planning application 3/2024/0613 Inglemeades

I have discussed my concerns re parking provision for a 2 bed new dwelling. I cannot understand [REDACTED] LCC Highways comments on this application, which appear to have been carried over from the previous application ( 3/2020/1015) and the comments of [REDACTED] LCC Highways. This states "that only a single parking space is necessary considering the location and its relation to the town centre. This is also inconsistent advice.

PL.01

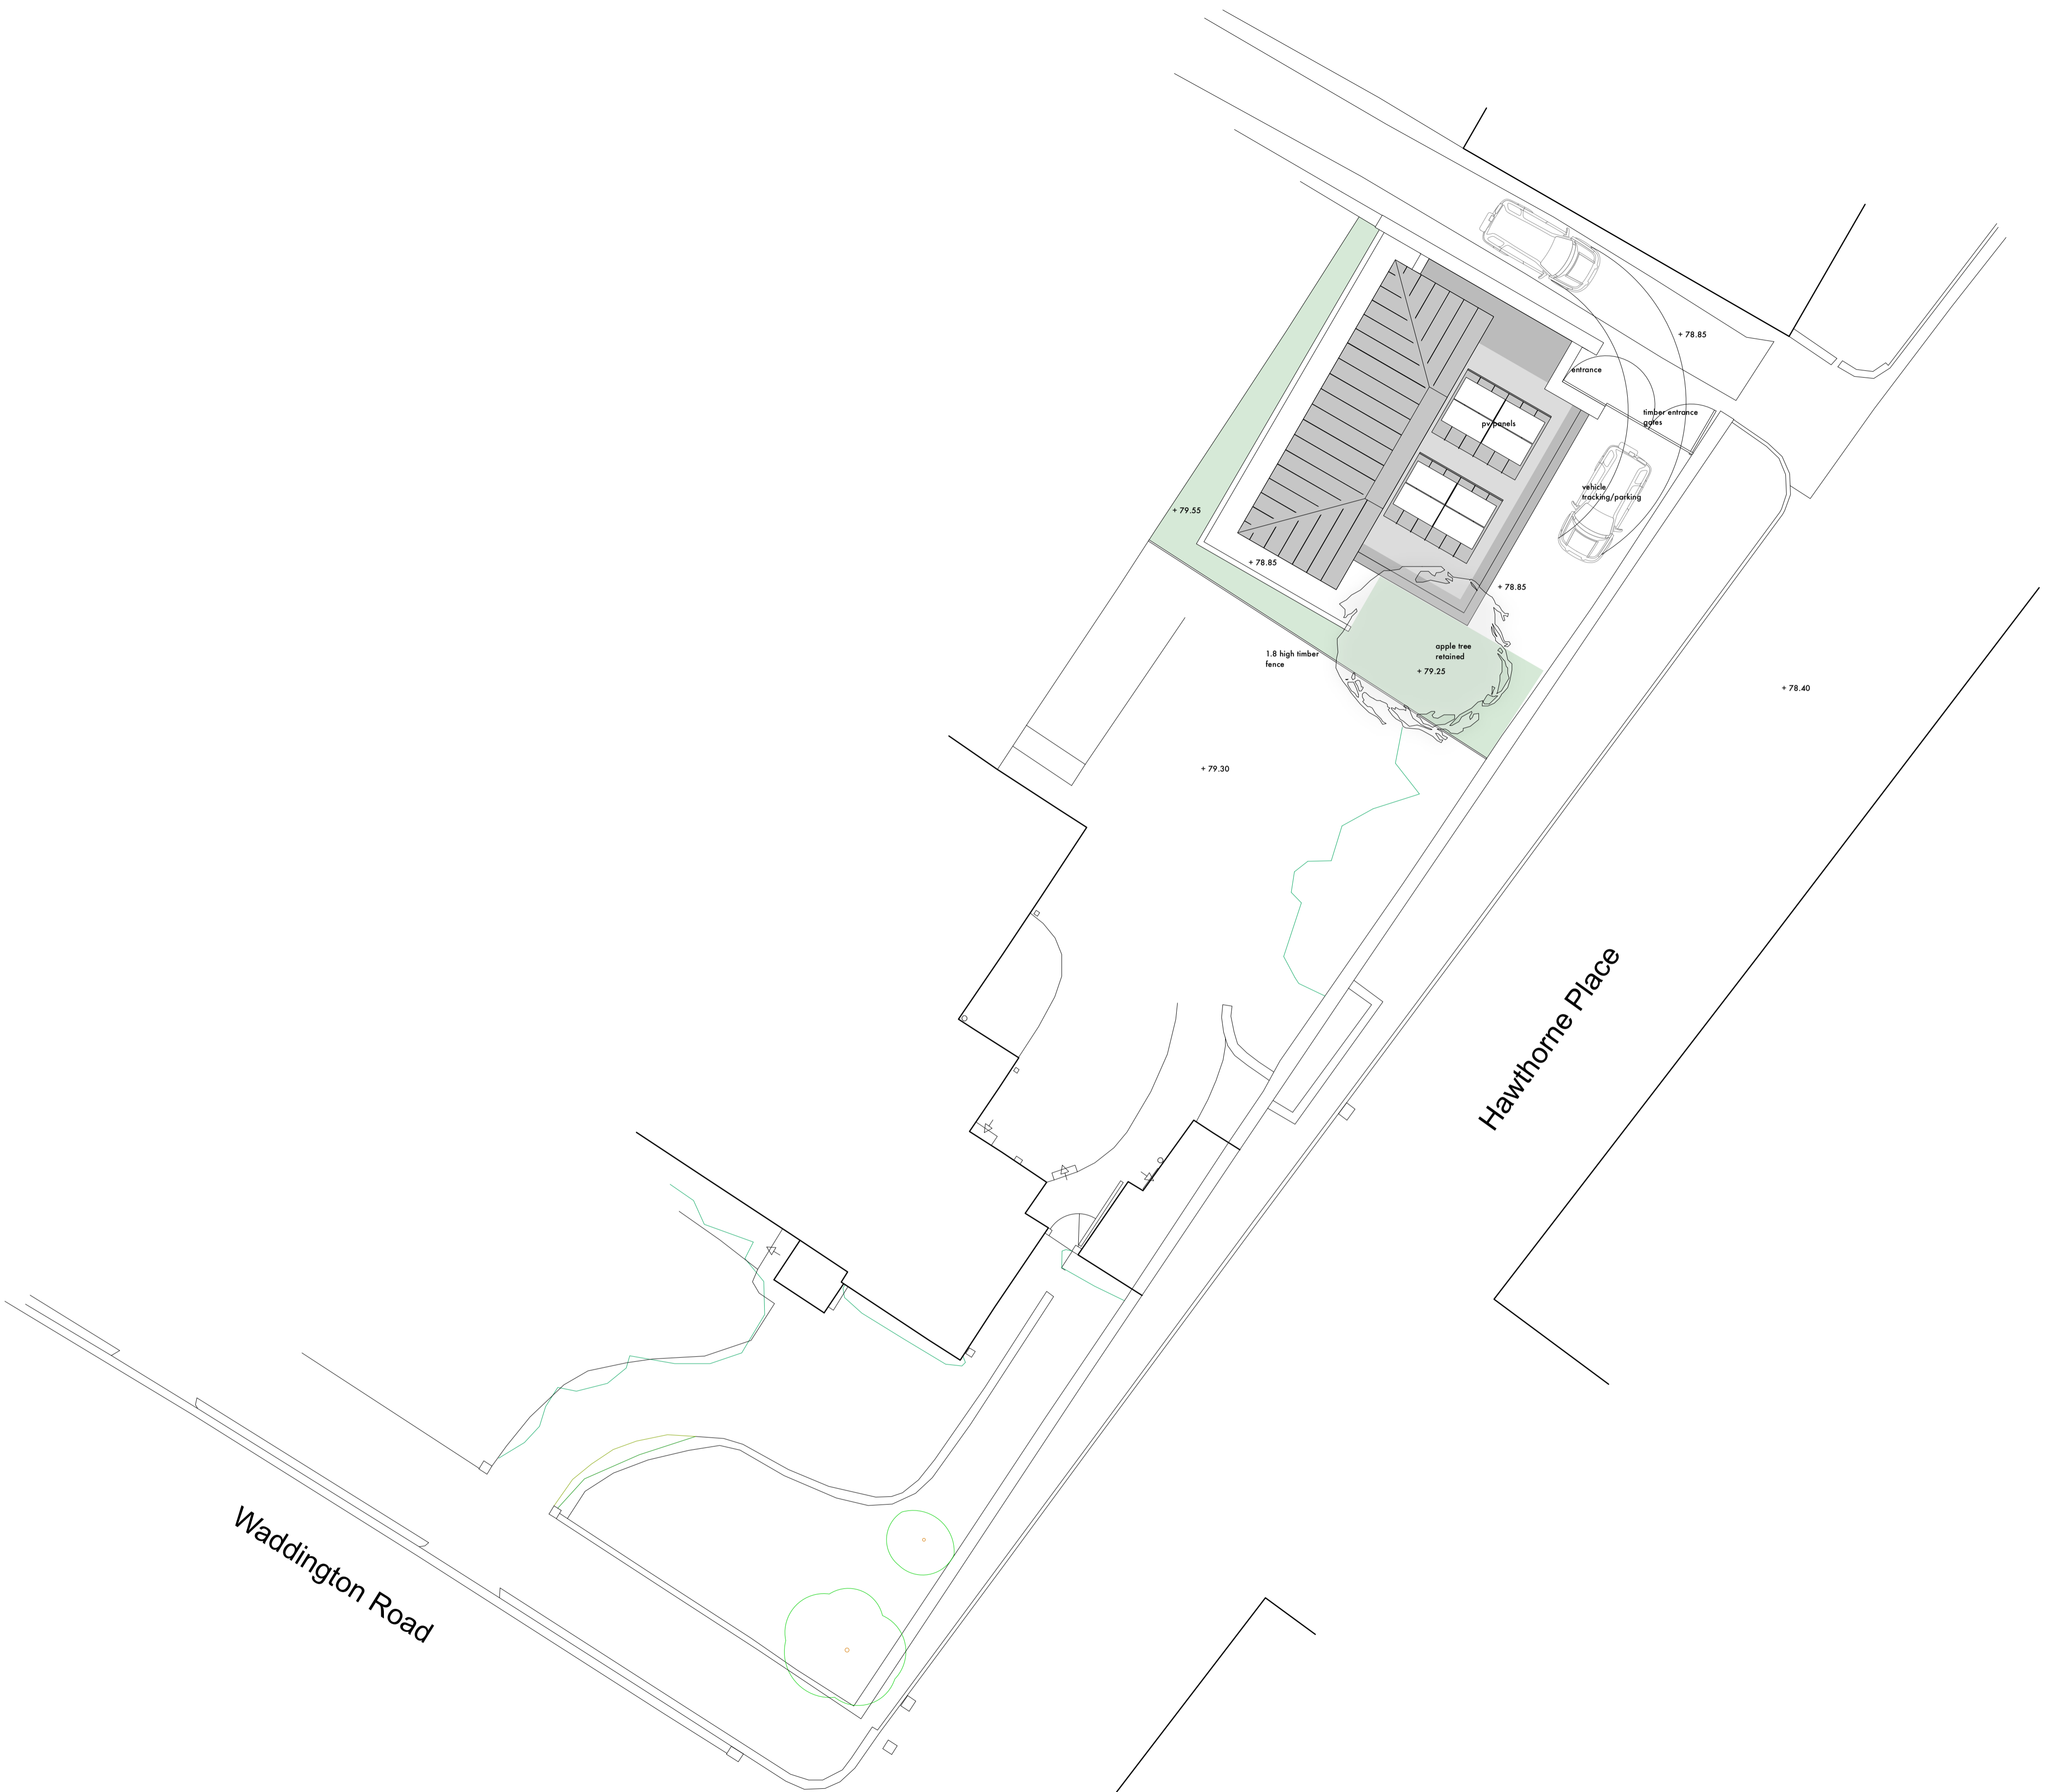
[REDACTED] has previously commented on the Barratt Homes development at Waddow Heights and he stated " parking should be provided at the following levels commensurate with the size ( number of bedrooms per property) 1 bed 1 parking space, 2 to 3 beds - 2 parking spaces, 4+ - 3 parking spaces" This development and the location of the 2 bed homes is actually closer to the town centre/ train station than the rear garden of Inglemeades. The 2 bed homes on this development each have 2 designated parking spaces.

Please consider this as a reasonable objection to parking provision for this planning application. I am not being patronising in any way to [REDACTED] but have genuine concerns re parking on Hawthorne Place and wish equality and fairness in LCC planning application response.

Regarding the above planning application ,the proposed development was allowed only one off road parking space rather than the two recommended for a two bedroom property due to the site’s proximity to the town centre.

However,it has been brought to [Redacted] attention that two earlier housing developments ,one off Milton Avenue and another off Waddington Road had to have two spaces provided for two bedroom properties even though these lie closer to the said town centre therefore showing “inconsistency” in planning rules .

We therefore request that LCC Highways are made aware of this inconsistency and reconsider the application.
